Recommendation Report for Planning Permission for Works or Extension to a Dwelling

REF NO: FG/42/20/HH

LOCATION: 41 Sea Lane Gardens
Ferring
BN12 5EQ

PROPOSAL: Demolition of existing garage and erection of single storey side and rear extension.

Existing and proposed ground floor plan

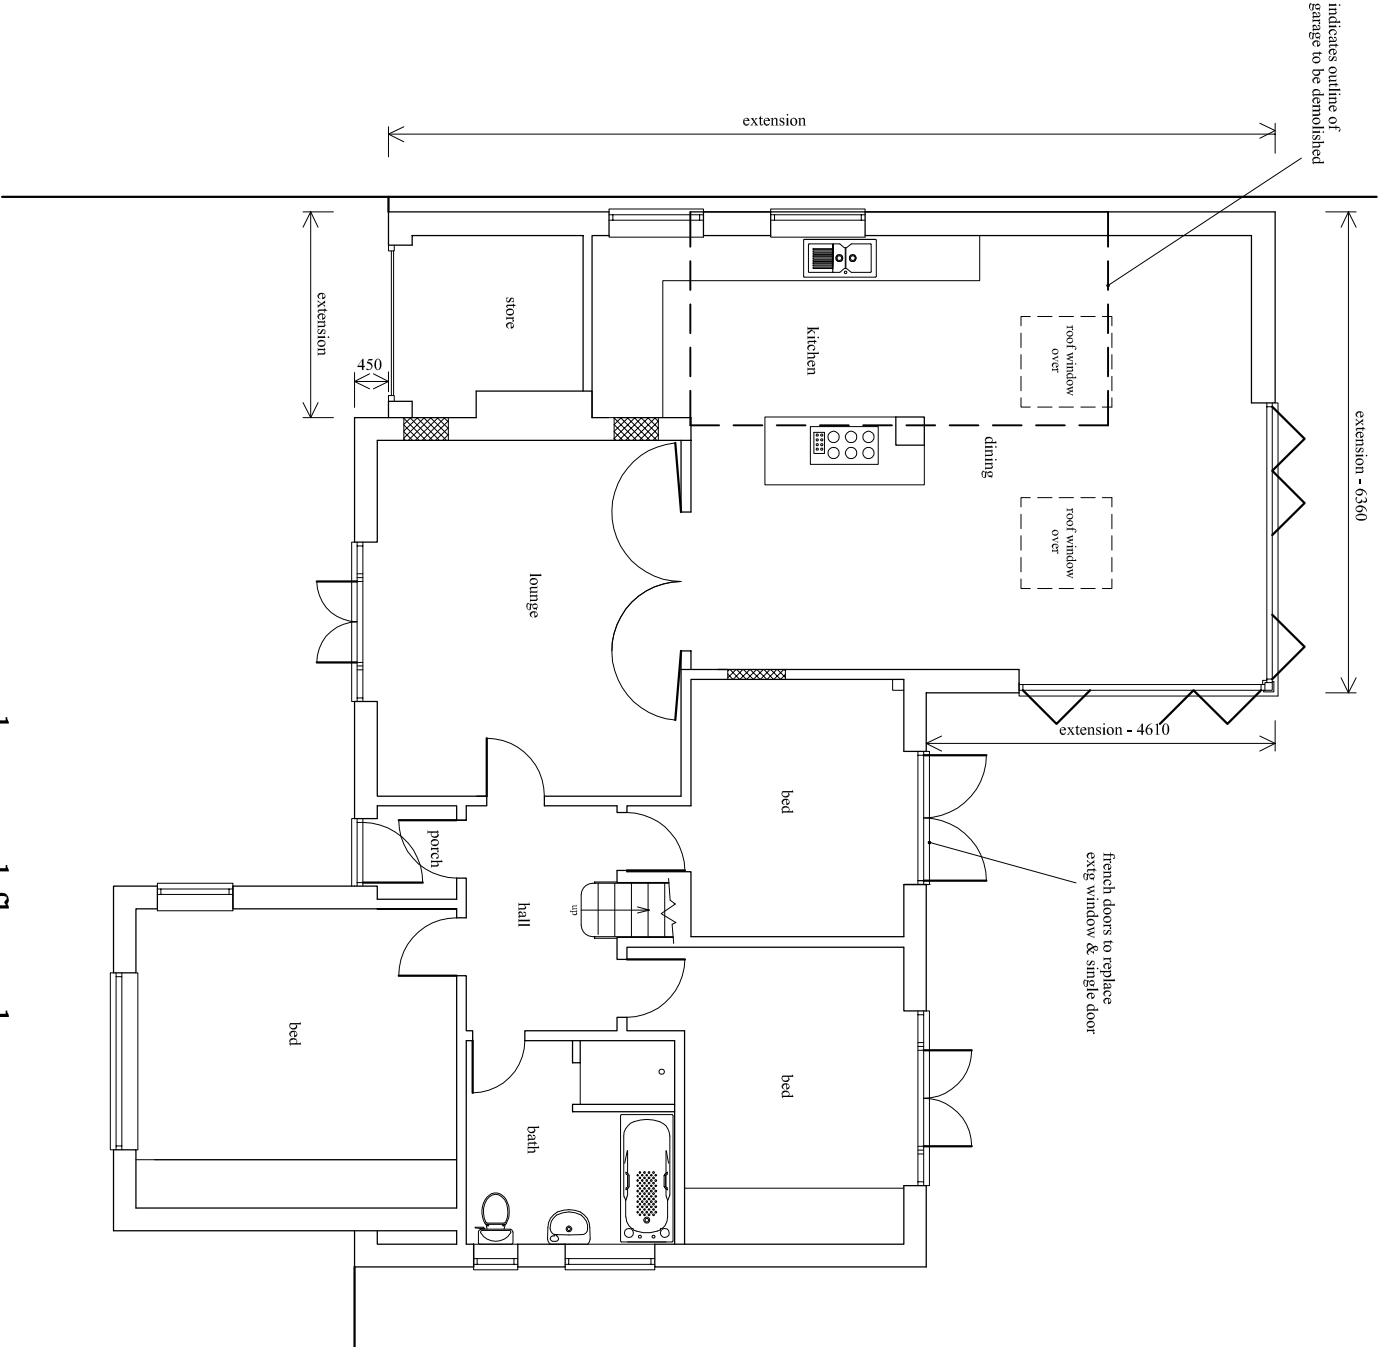
The rear element of the proposed development will be screened from public view due to the side extension, and as such, is not considered to have an impact upon the character of the host dwelling, or its locality.

Existing & proposed
front & rear elevations

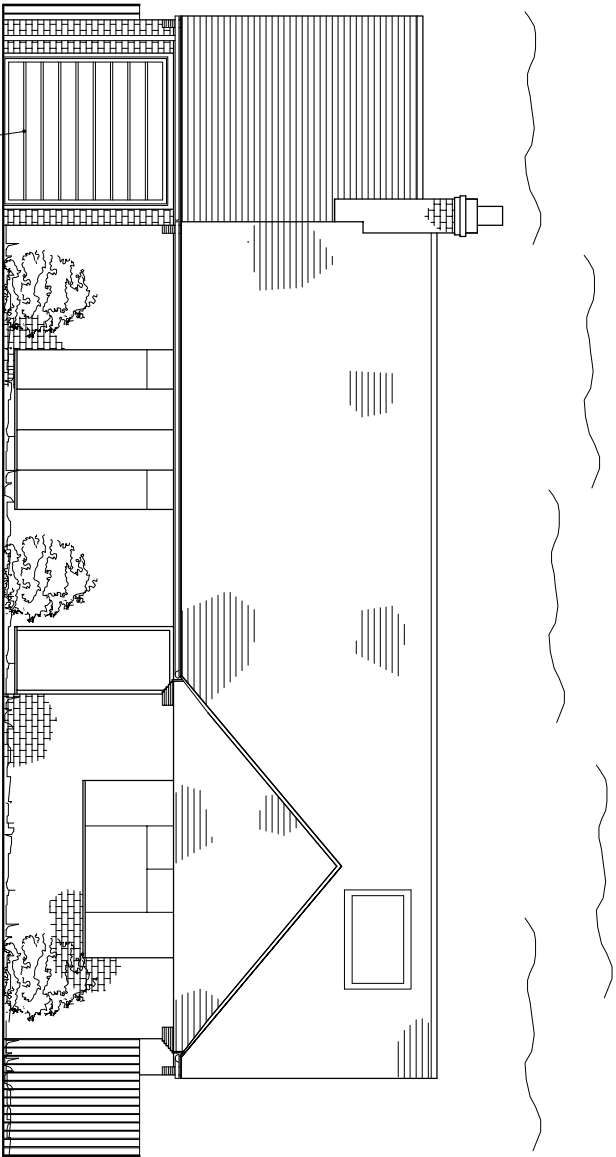
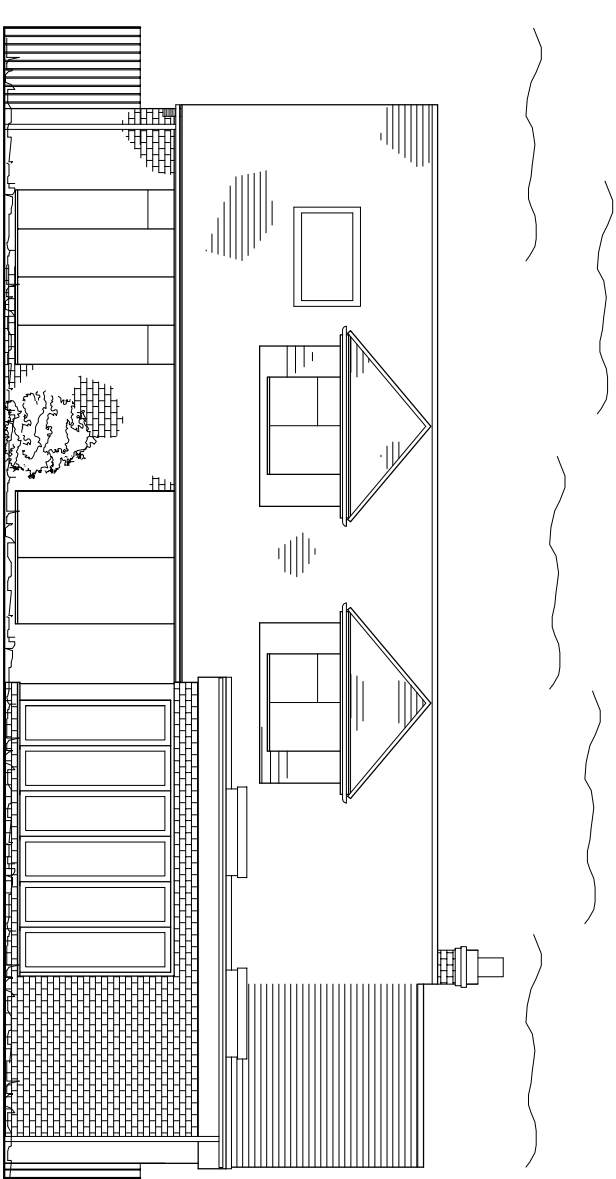
Due to its siting, the proposed development will be visible within the street scene. However, the proposed development is not considered to result in any significant impact upon the character of the locality, or its spatial pattern. The dwellings within the area are not deemed to have a uniform appearance, and have historically been extended in a multitude of ways. The proposed side extension has a maximum height of which is lower than the ridge height of the host dwelling, resultant of this and the proposed materials, the proposed extension is considered to appear subservient to, and well integrated with the host dwelling.

- 3 The materials and finishes of the external walls (and roof of the building hereby permitted shall match in colour and texture those of the existing building.

Existing & proposed
side elevations

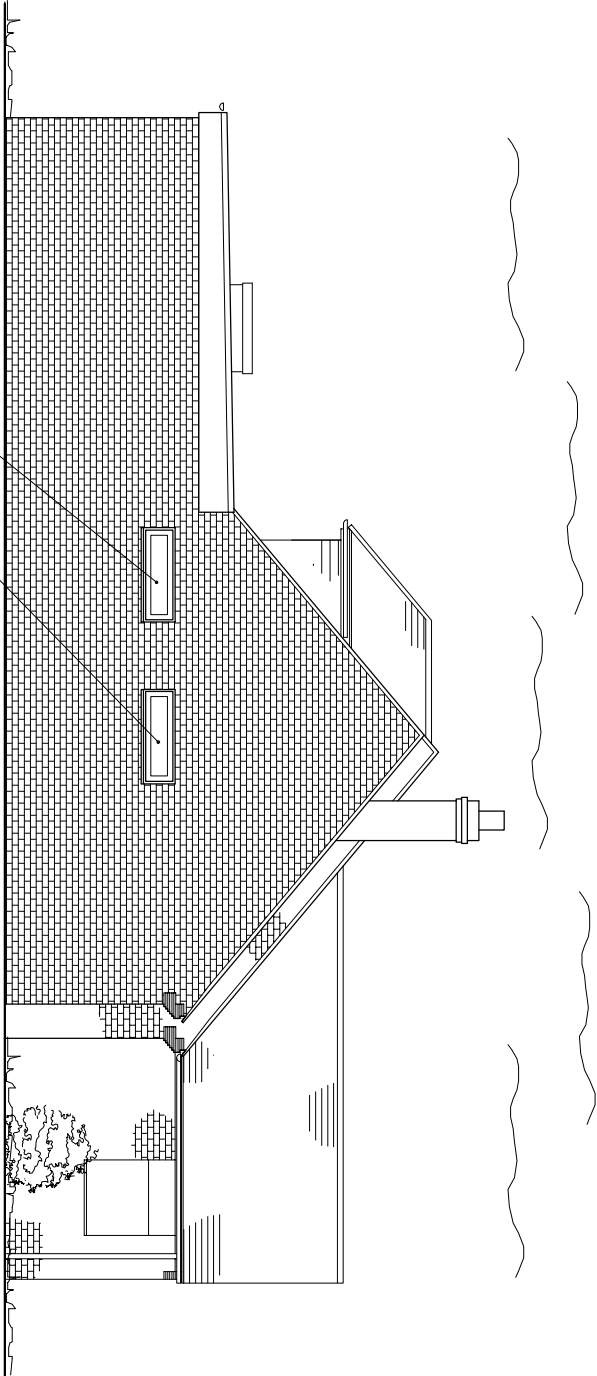
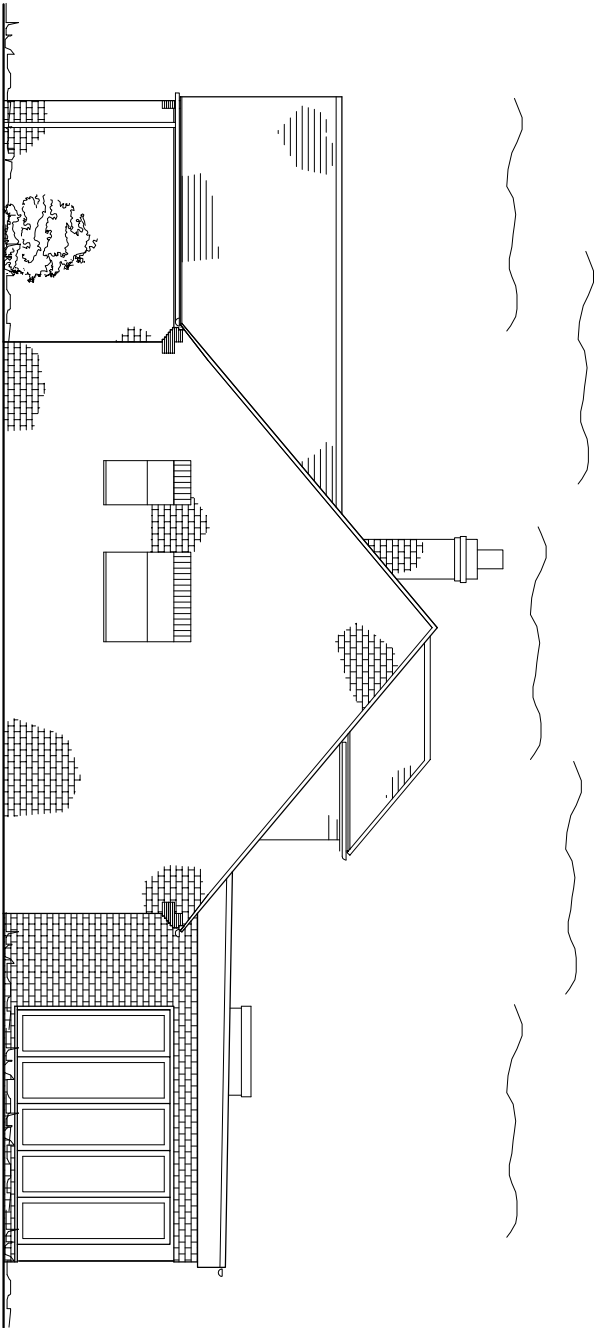
The proposed development is not considered to result in any significantly harmful impact upon the residential amenities of neighbouring dwellings, by way of overshadowing or overbearing impact. This is due to the siting of the proposed development, as it projects forward of the host dwelling. The area of the neighbouring property to the South is used as a parking area, and therefore, any potential overbearing impact does not affect primary habitable rooms, or private amenity areas of the neighbouring dwelling. There is not considered to be any loss of privacy as a result of the development, due to the lack of openings of which could result in this harm.
